From: Simon Davis
Sent: 14 June 2017 17:58
To: Planning.Responses
Subject: FW: Application BE/63/17/OUT - The Cottage, Shripney

App No: BE/63/17/OUT

Address: The Cottage Shripney Road Bognor Regis PO22 9PA

Proposal: Outline planning application with some matters reserved (Access only) for 20No. houses & flats, 1No. replacement dwelling (21No. units in total) with car parking, landscaping & associated infrastructure & access off Shripney Road (A29), following the demolition of the existing dwelling & outbuildings. This application is a Departure from the Development Plan

Drg No. 334/P/03

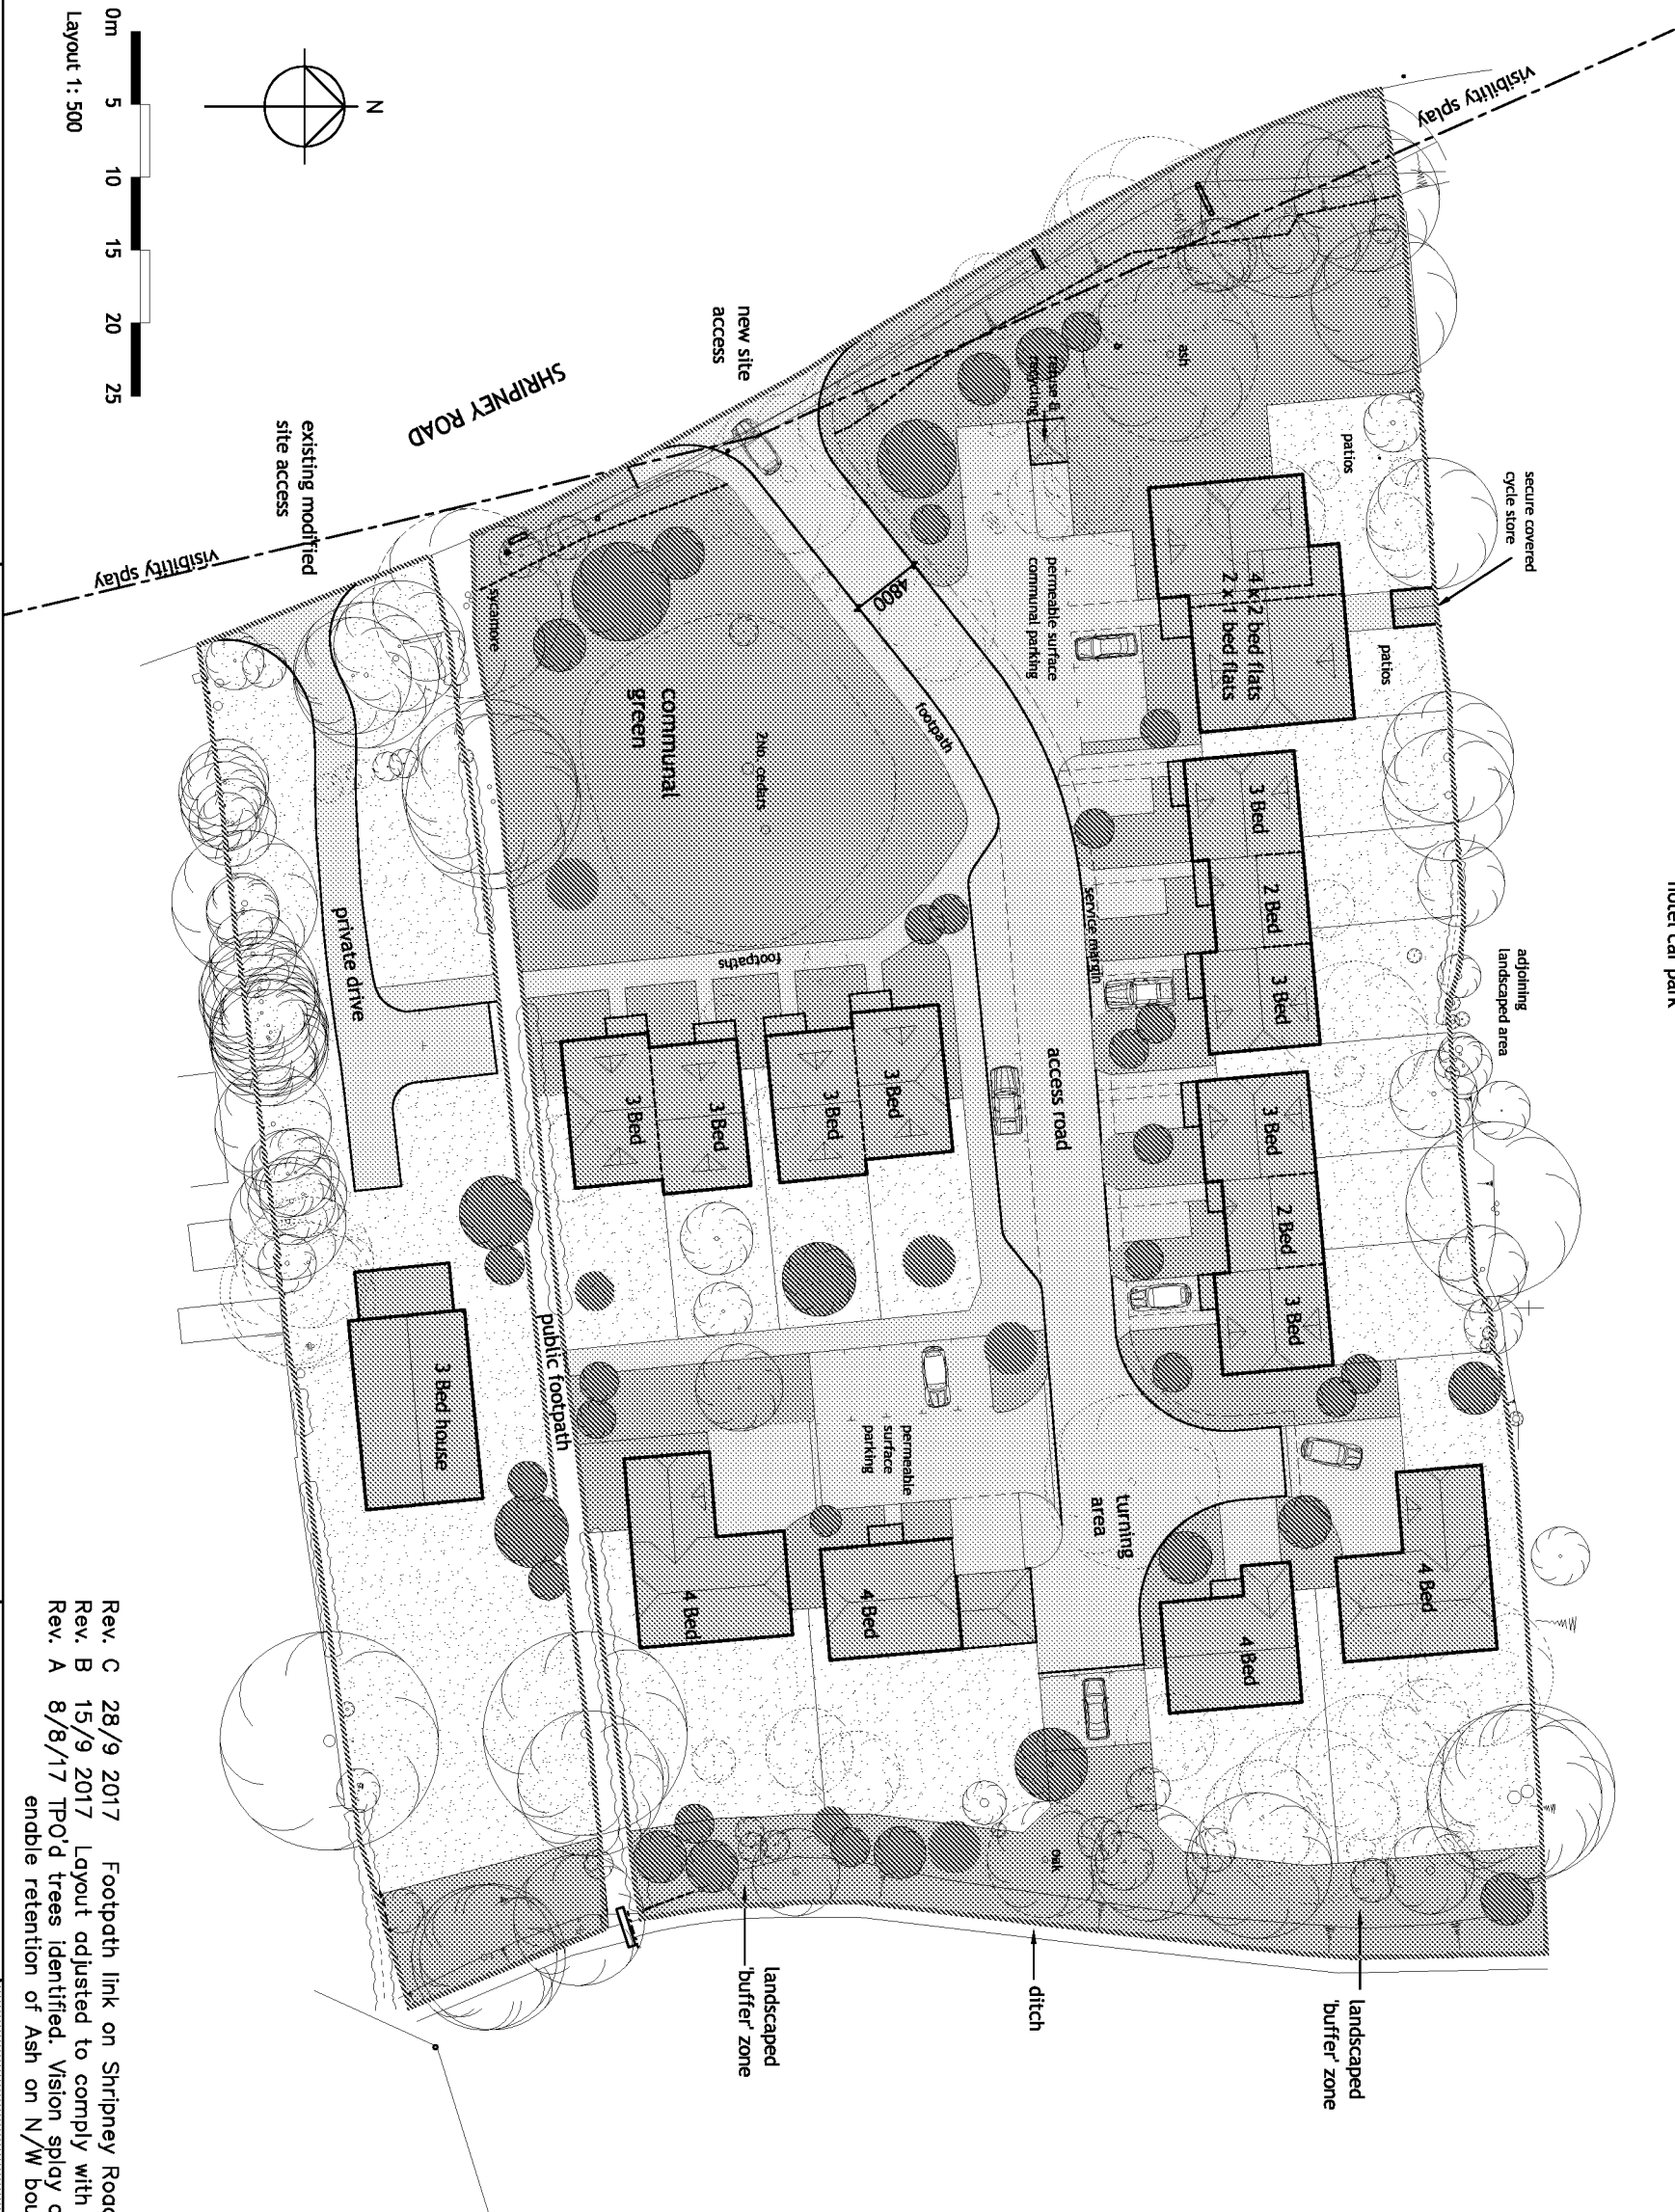
The hedgerows on site are used by bats for commuting and foraging and will need to be retained and enhanced for bats. This will include having a buffer strip around the hedgerows (5m) and during construction fencing should be used to ensure this area is undisturbed. Any gaps should also be filled in using native hedge species to improve connectivity. Where any hedge is to be removed as detailed within the survey, new hedgerow should be planted. Conditions should be used to ensure this.

Following the further survey work which took place to the trees onsite, though no bats were found (as detailed within the Bat Activity Survey June 2017) as a precautionary approach any trees which are scheduled to be removed should be done by soft felling. Tree 3 is being retained so no surveys were done on this area. If this changes, a survey would be required
